Application No: MP07_0158 MOD 3

Exhibition of Modification Request for the University of Sydney Abercrombie Precinct Redevelopment

Date: 10 November 2013

S75w Submission OCTOBER 2013 ABERCROMBIE STUDENT ACCOMODATION View from Abercrombie Street (without existing trees)

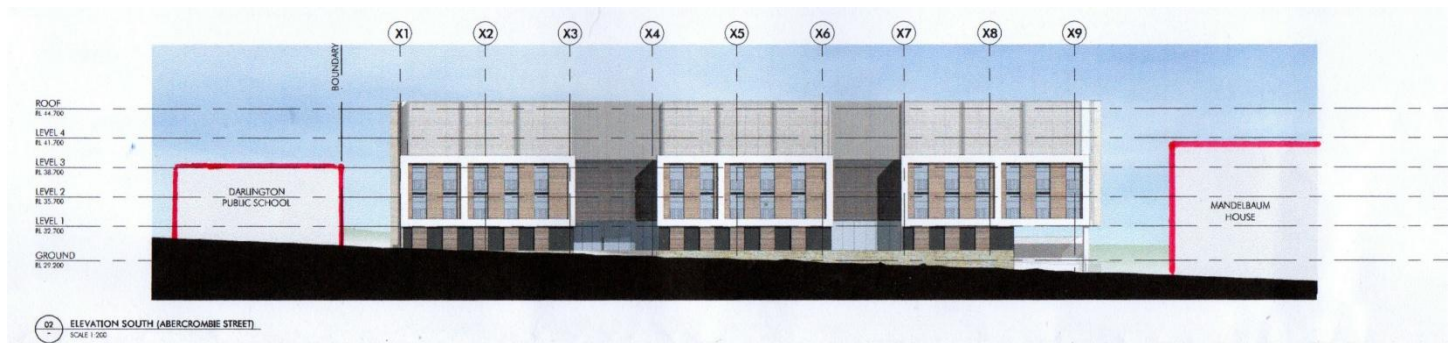
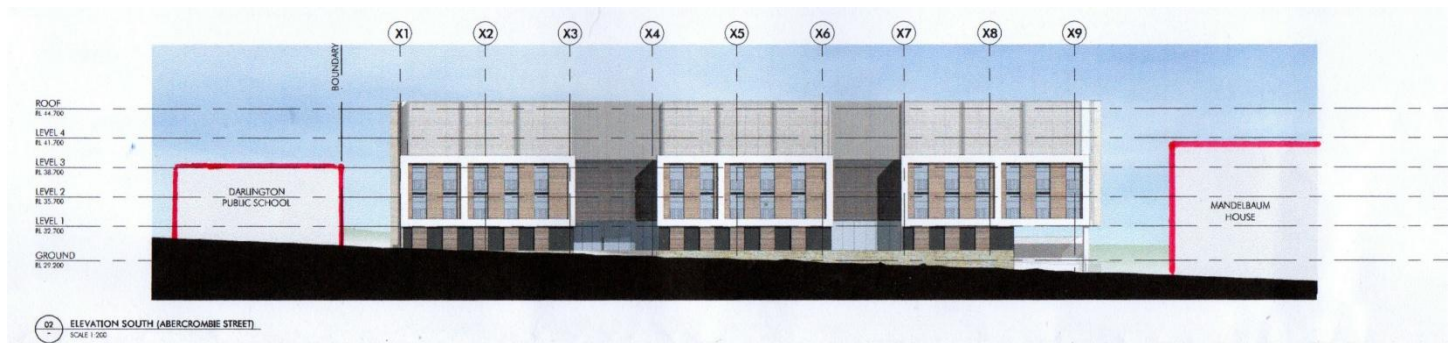
This picture is grossly inaccurate in its depiction of the perspective and proportions:

- The people walking along the street in the picture would only just fit into the rooms on the ground floor. It appears as though the building would be built below ground level. However, this is not the case.
- The Darlington Public School building in the left of this picture is a 2 storey building yet appears to be the same height as the 5 storey Student Accommodation next door.
- The University's own picture below gives a truer idea of the way in which the Student Accommodation would be much higher than the Darlington Public School building to the left and also Mandelbaum House to the right.

Once again, it appears that the University is not being completely honest with residents by misrepresenting the 3D rendered image above in order to make the building appear much smaller than it would actually be.

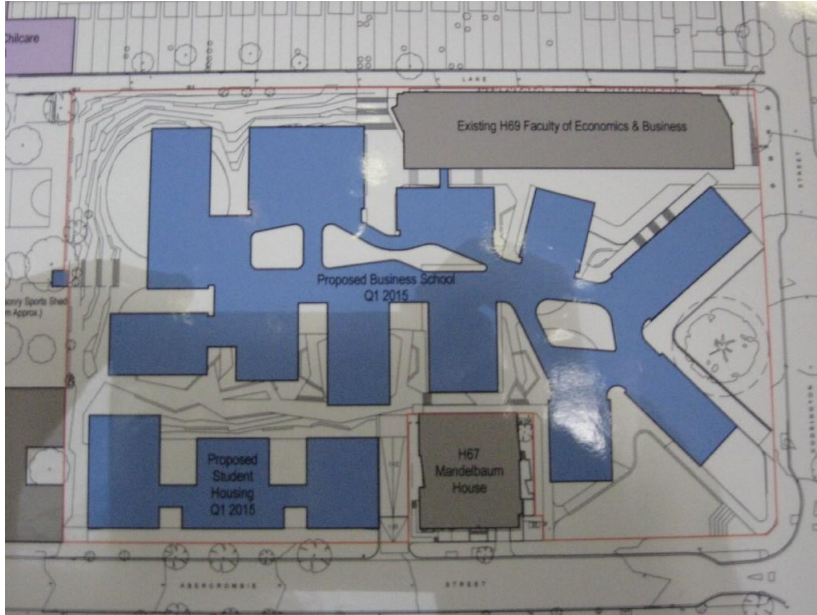
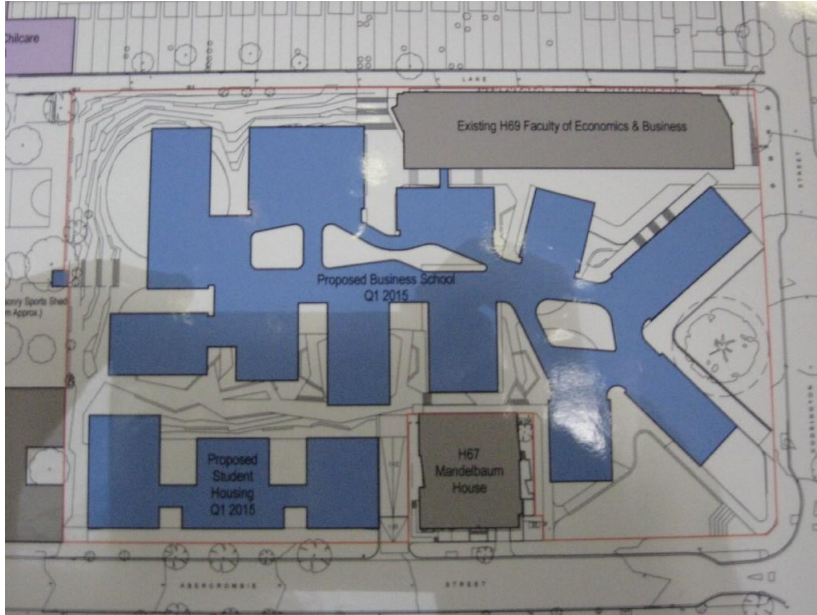
- The University's own elevation below clearly shows that Darlington Public School, outlined in red on the left of the picture, is a 2 storey building which sits well below the 5 storey Student Accommodation.
- The red line at the top of Mandelbaum House on the right of the Student Accommodation is actually the height of its pitched roof.

Many objections made to the original plans for the APD Business School and Student Accommodation buildings were on the basis of their height, bulk and scale, especially as they are proposed to stand much higher than Mandelbaum House to the east and Darlington Public School to the west, dwarfing both of them.

The scale of the proposed Student Housing building along Abercrombie Street is up to five storeys, which is out of character with the prevailing height and scale of the 2-3 storey Victorian terraces on the southern side of Abercrombie Street and a number of other traditional buildings mainly located at the intersection between Abercrombie Street and Codrington Street.

- The building should be reduced in height and scale so that it is consistent in height with Mandelbaum House and conforms to the established 2-3 storey characteristic height of buildings along Abercrombie Street.

Figure 1 - Extract from architectural plans – showing the Student Housing Building is out of scale with the streetscape and far higher and bulkier than Mandelbaum House and Darlington School

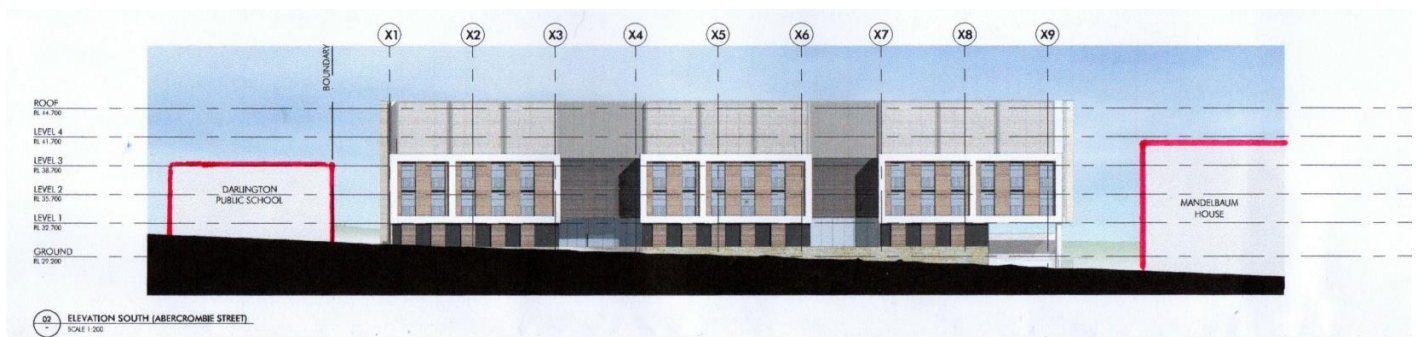
It is also out of scale with Mandelbaum House, which was designed to complement the Abercrombie Street streetscape.
